Date: 02 December 2025
Our ref: 534129
Your ref: EN010142

Planning consultation: Application by One Earth Solar Farm Limited for One Earth Solar Farm. The Examining Authority's written questions and requests for information (ExQ3)
Location: One Earth Solar Farm

Annex A: Natural England's Response to the Examining Authority's Third Written Questions

Annex B: Natural England's Updated Comments on Cumulative Assessment of Soils from D4

Drawing Title:
Figure 18.4: Soils and BMV
Spatial ZOI

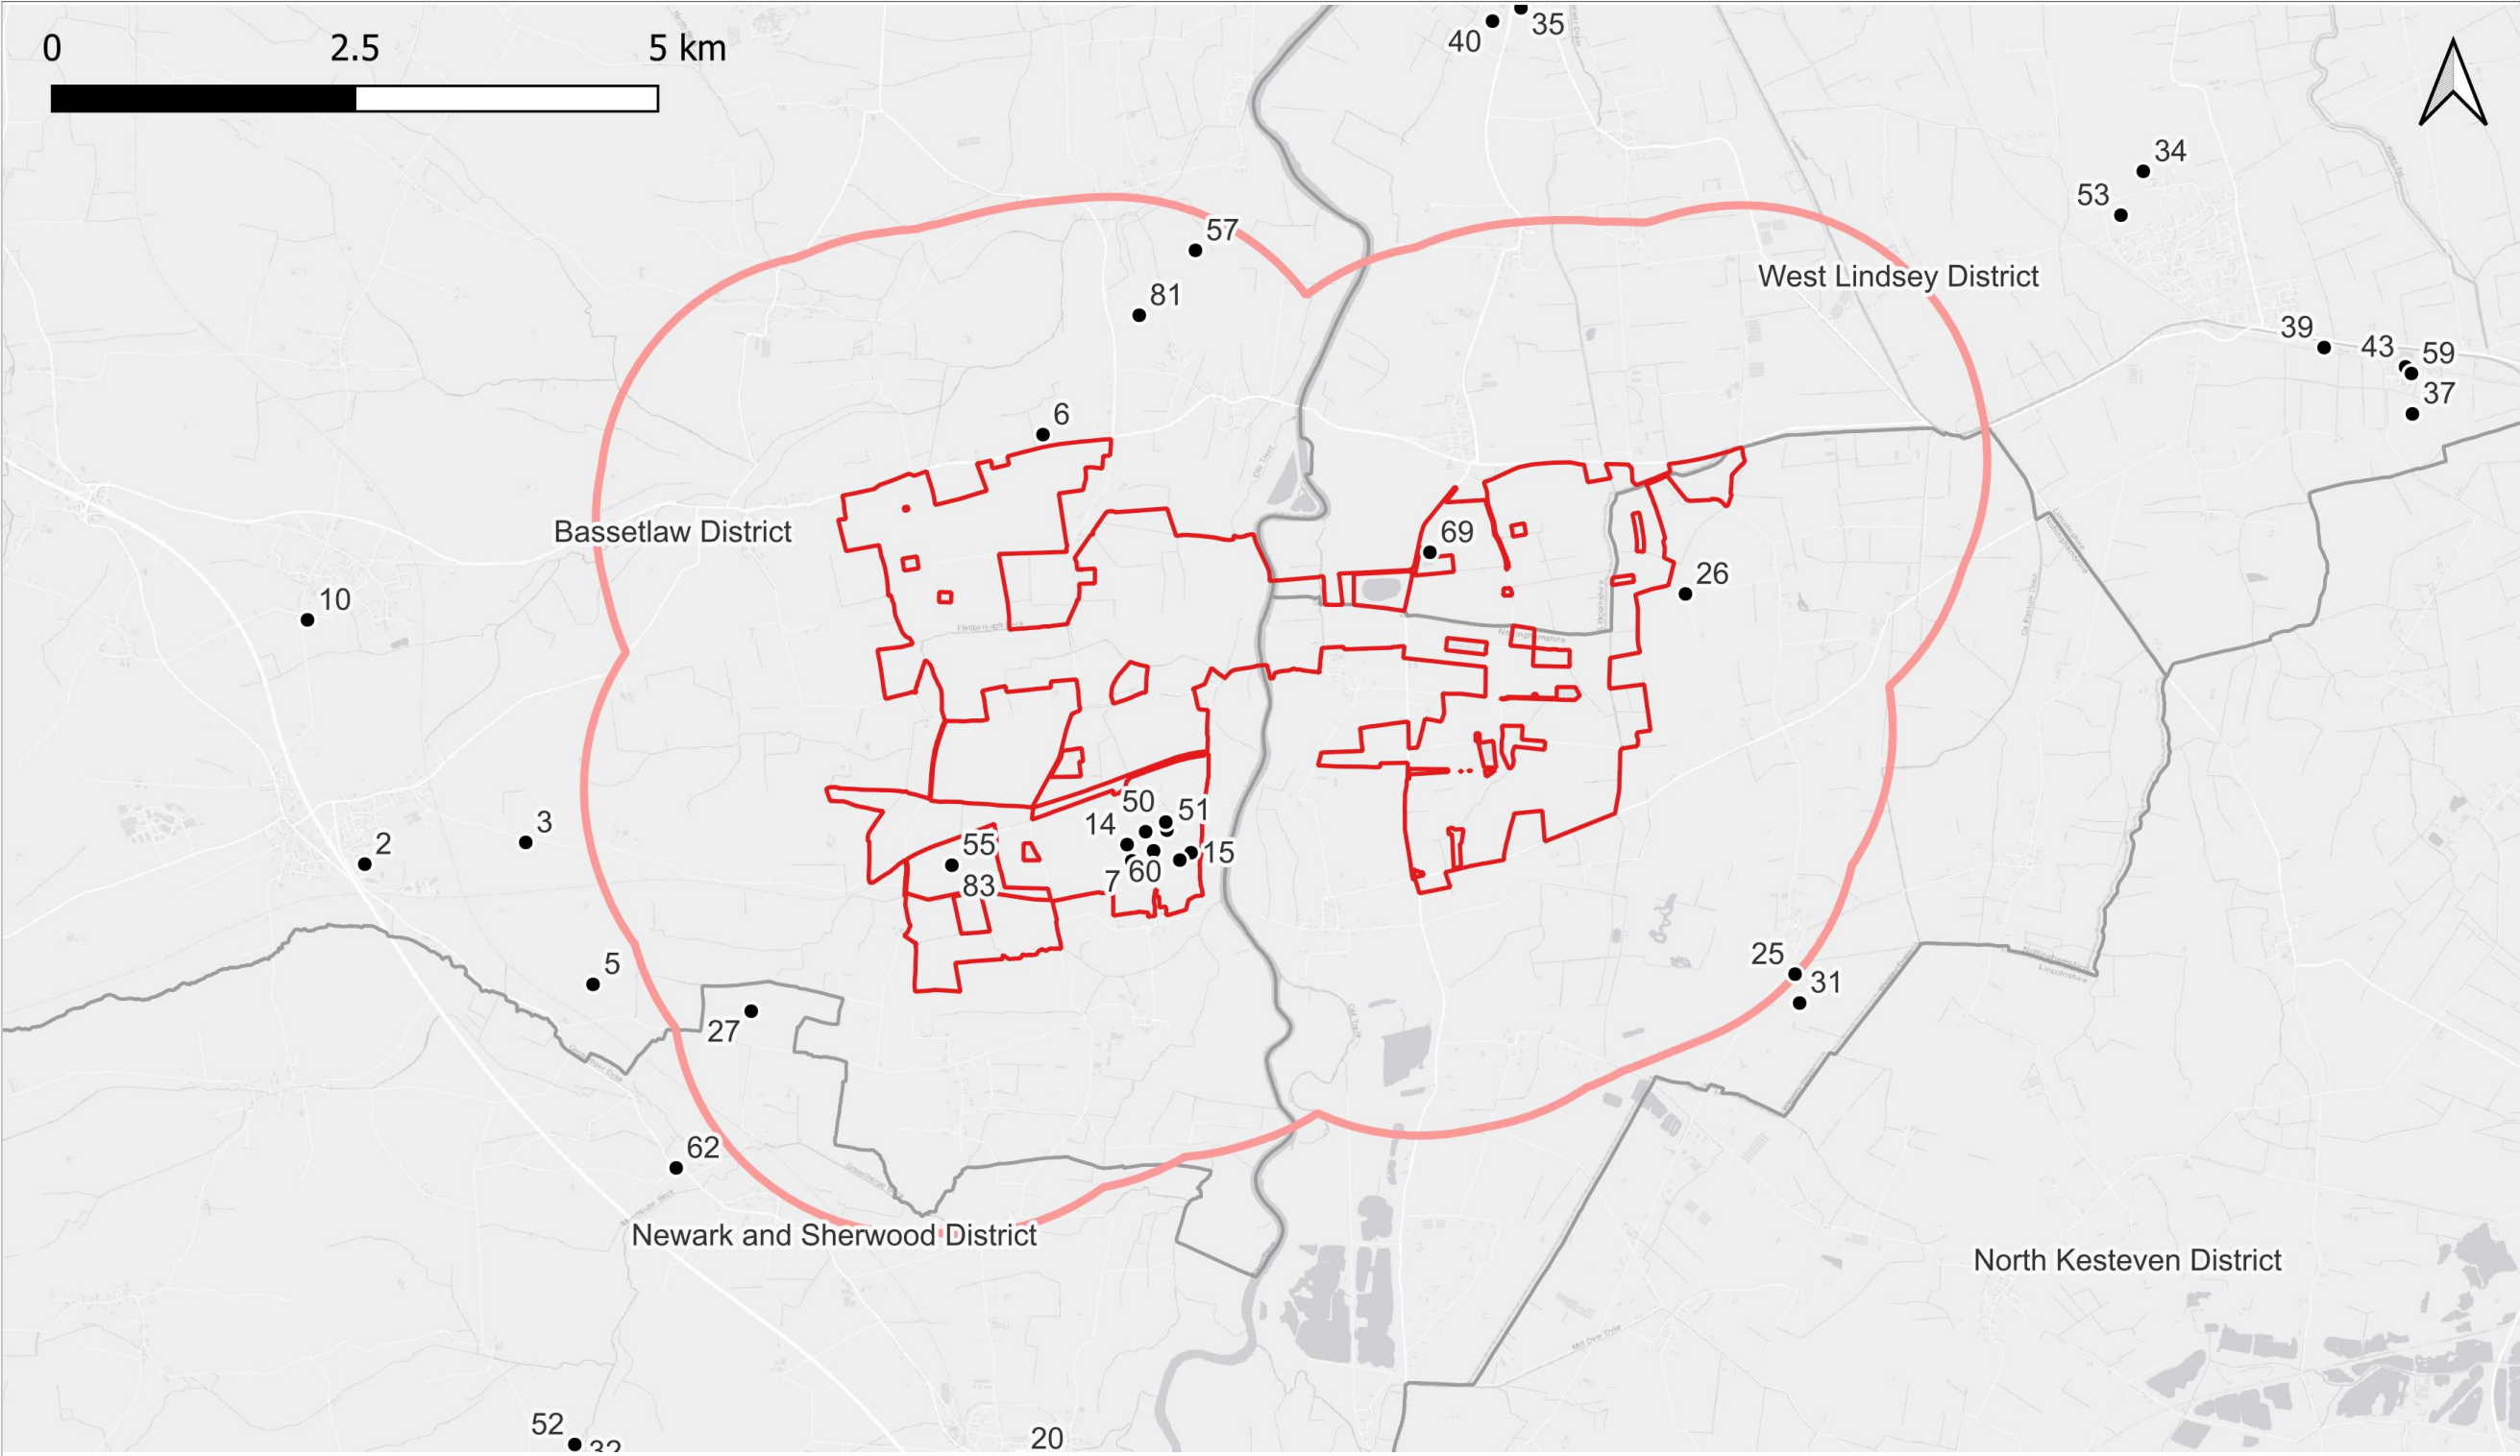
18.3.19 Natural England are broadly satisfied with the regional Zol and the information provided within ES Volume 3, Figures 18.1 to 18.8 [EN010159/APP/6.20] for a regional cumulative assessment, however we refer the applicant back to the comment above (table 18.2)

D6 Update: No further comment.
